CITY OF ALBUQUERQUE

**Re: APS Food Services Building Grading and Drainage Plan
Engineer's Stamp date 7-28-09 (L21/D070)**

**Re: APS Food Services Building, Manzano Mesa Grading and Drainage Plan
Engineer's Stamp date 4-29-09 (L21/D070)**

SHEET NUMBER
C104

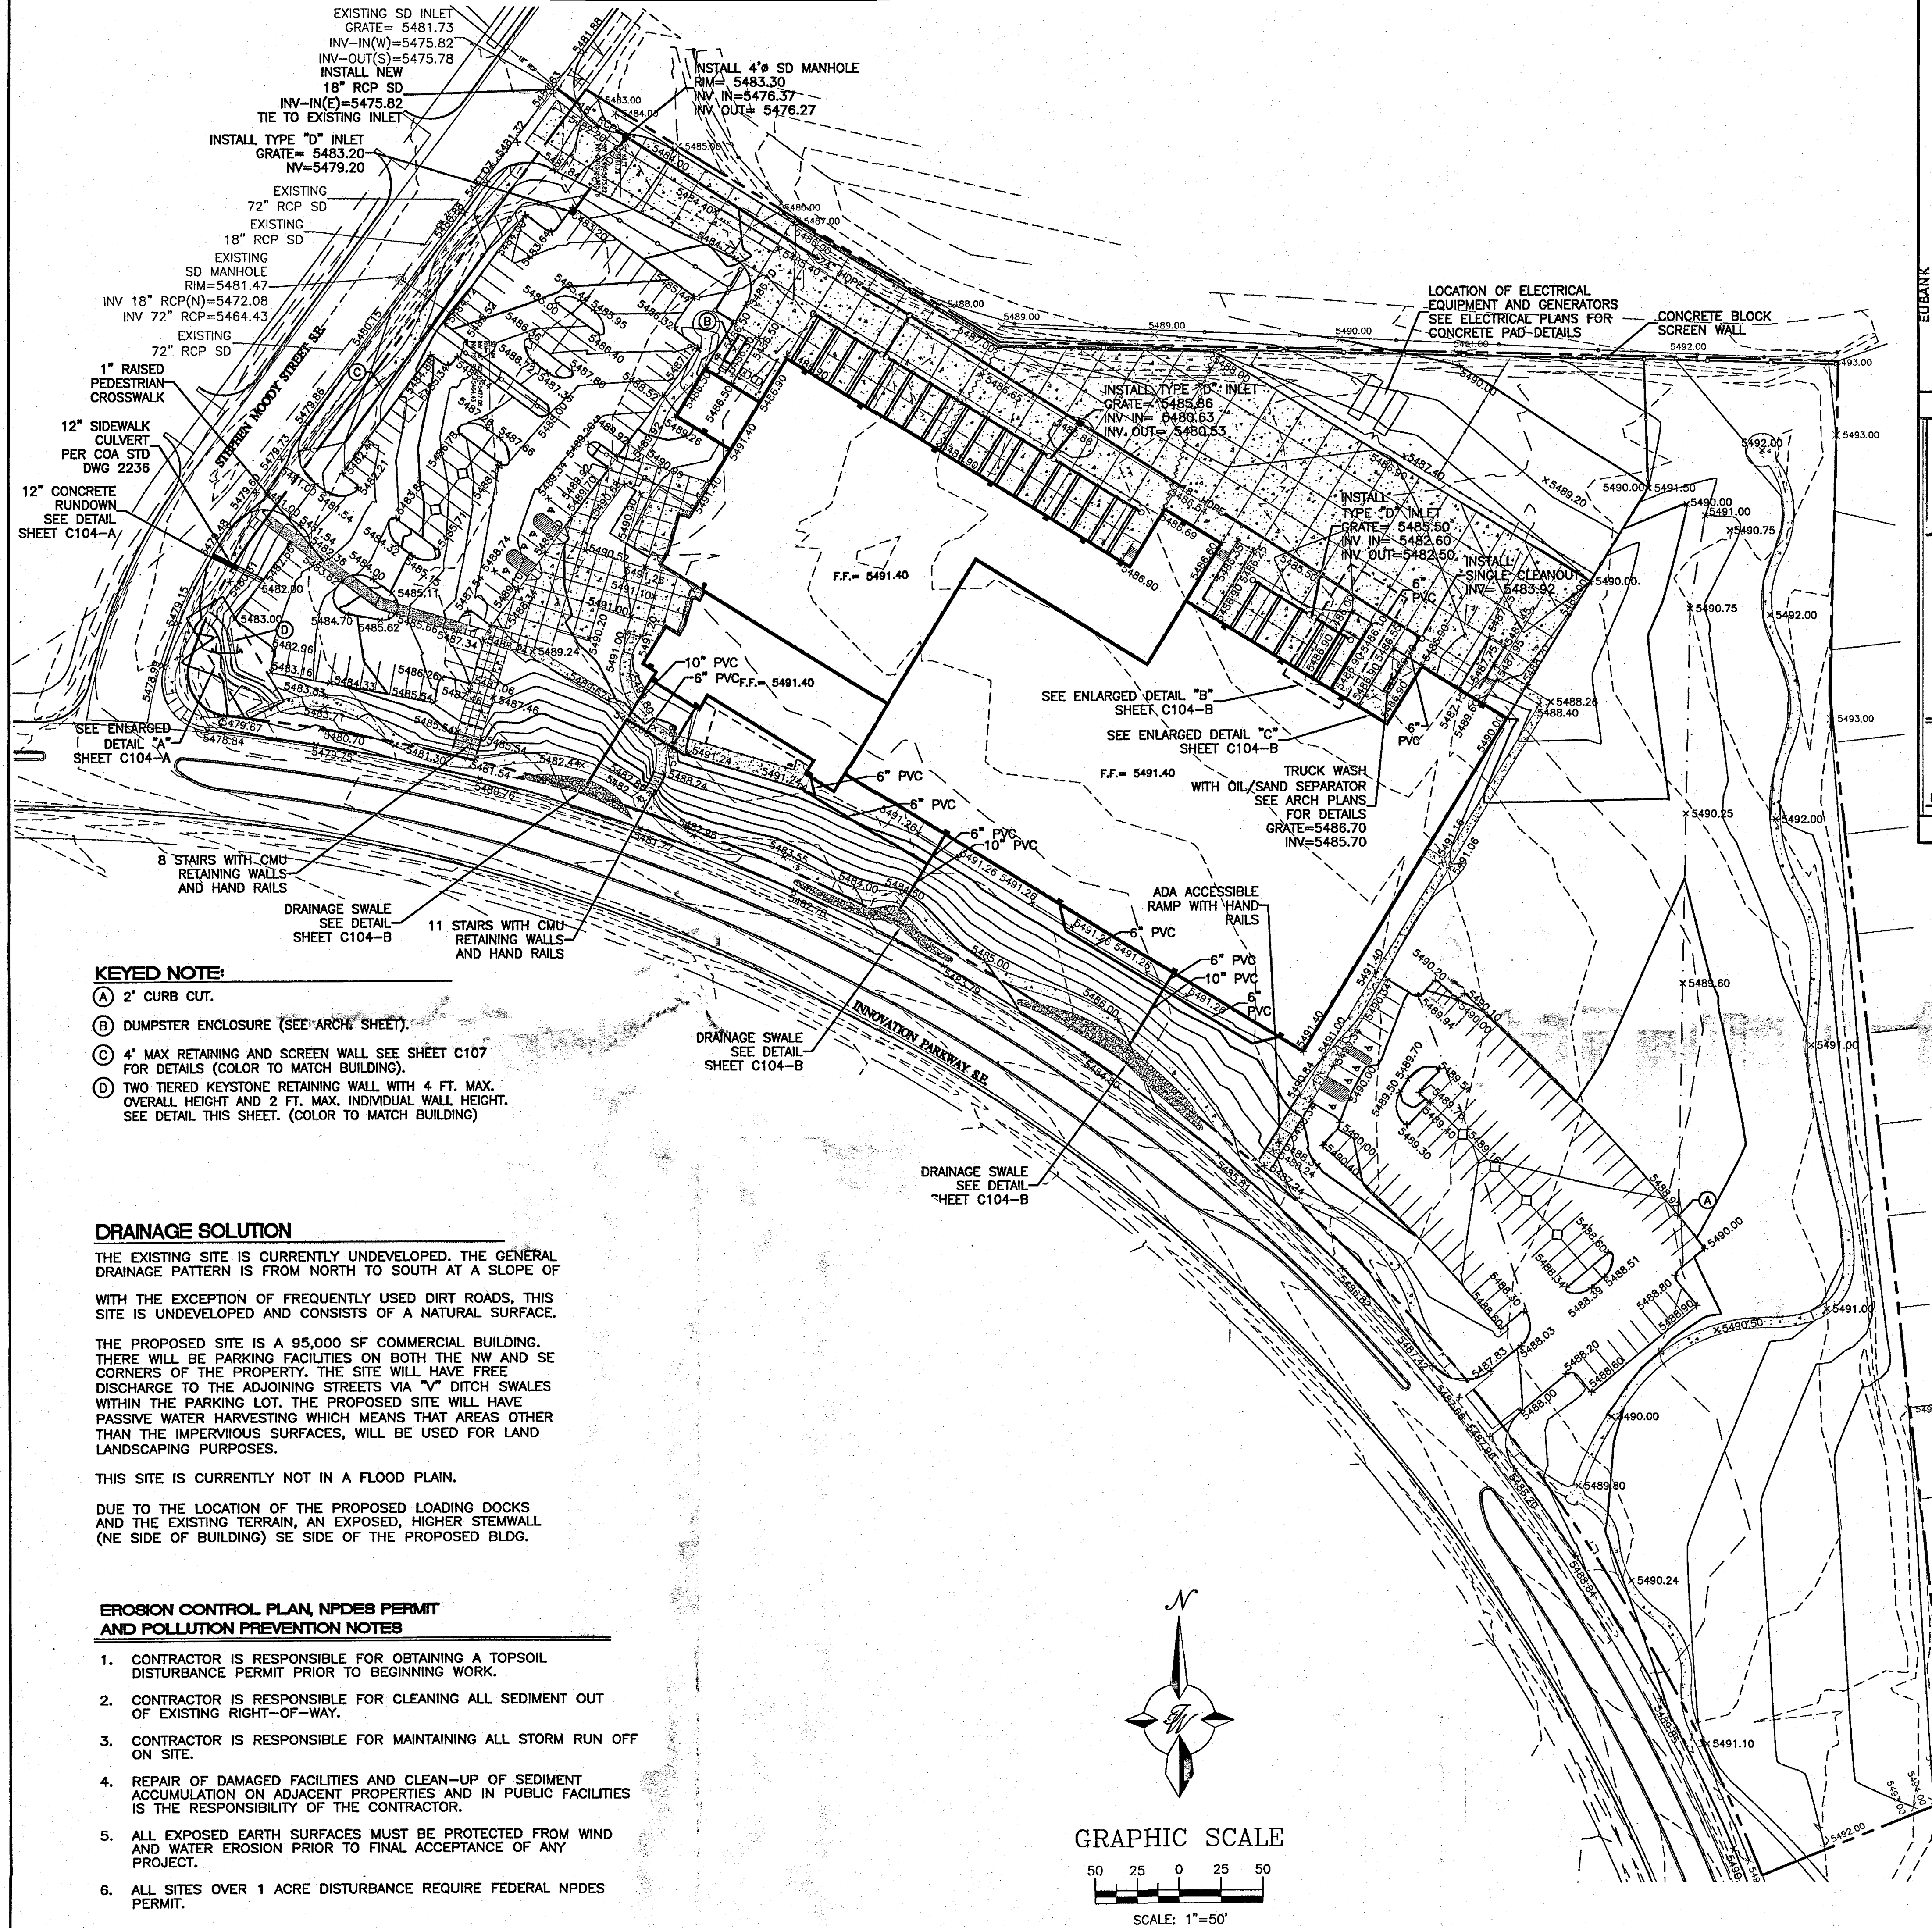
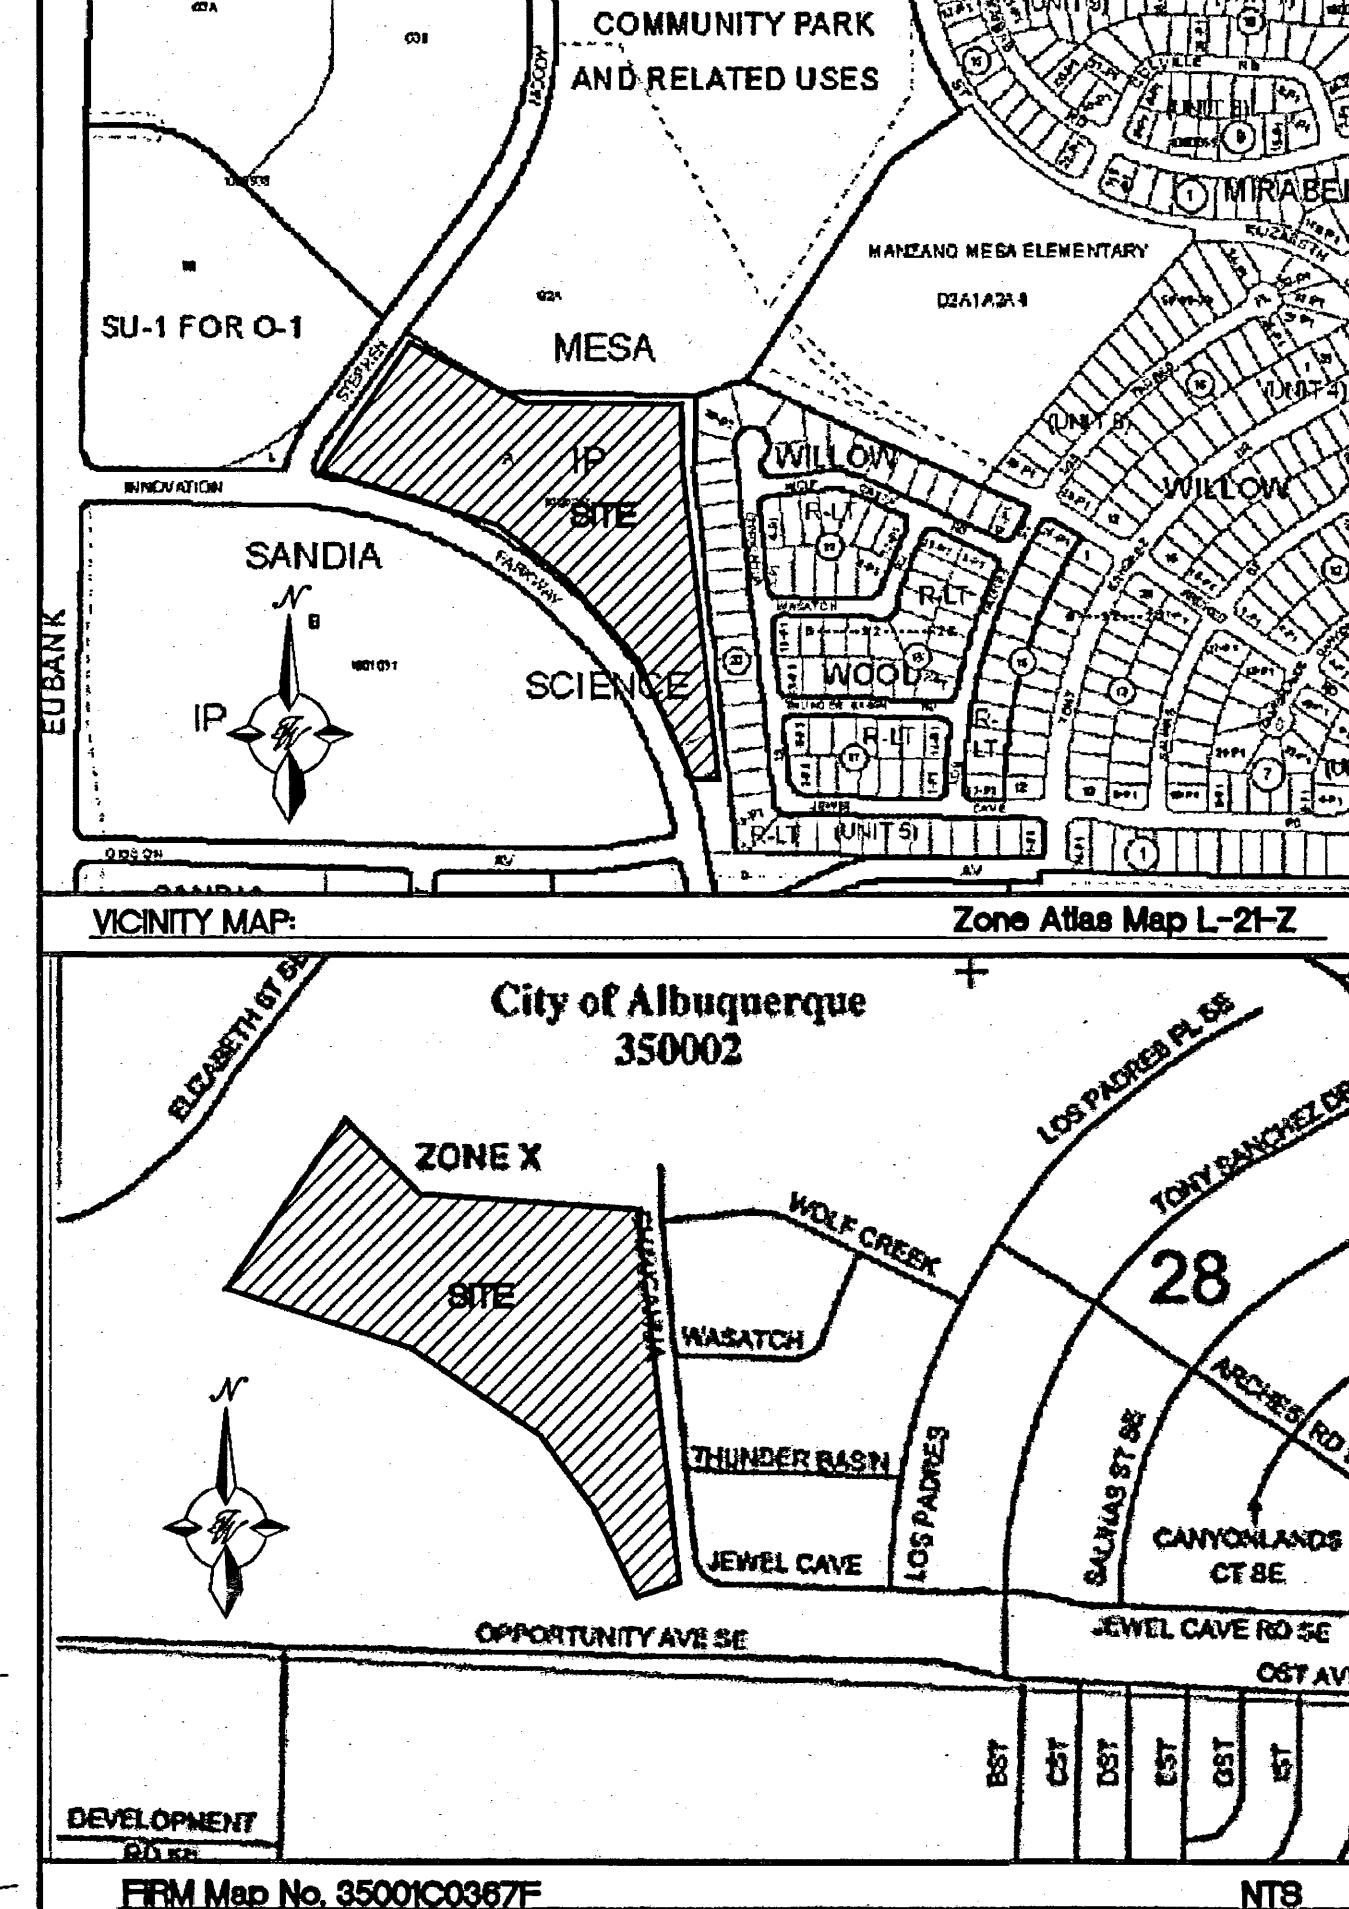
- fax copy of "reement"*
- Show the existing storm drain in Stephen Moody St. and the required new storm drain in Innovation Parkway Rd.
 - Propose a solution to minimize the drainage over the sidewalk.
 - The sidewalk culvert on Stephen Moody St. is required (STD DWG 2236) to extend to the face of curb.
 - Show the extent of the roof drain drainage swales on Plan View.
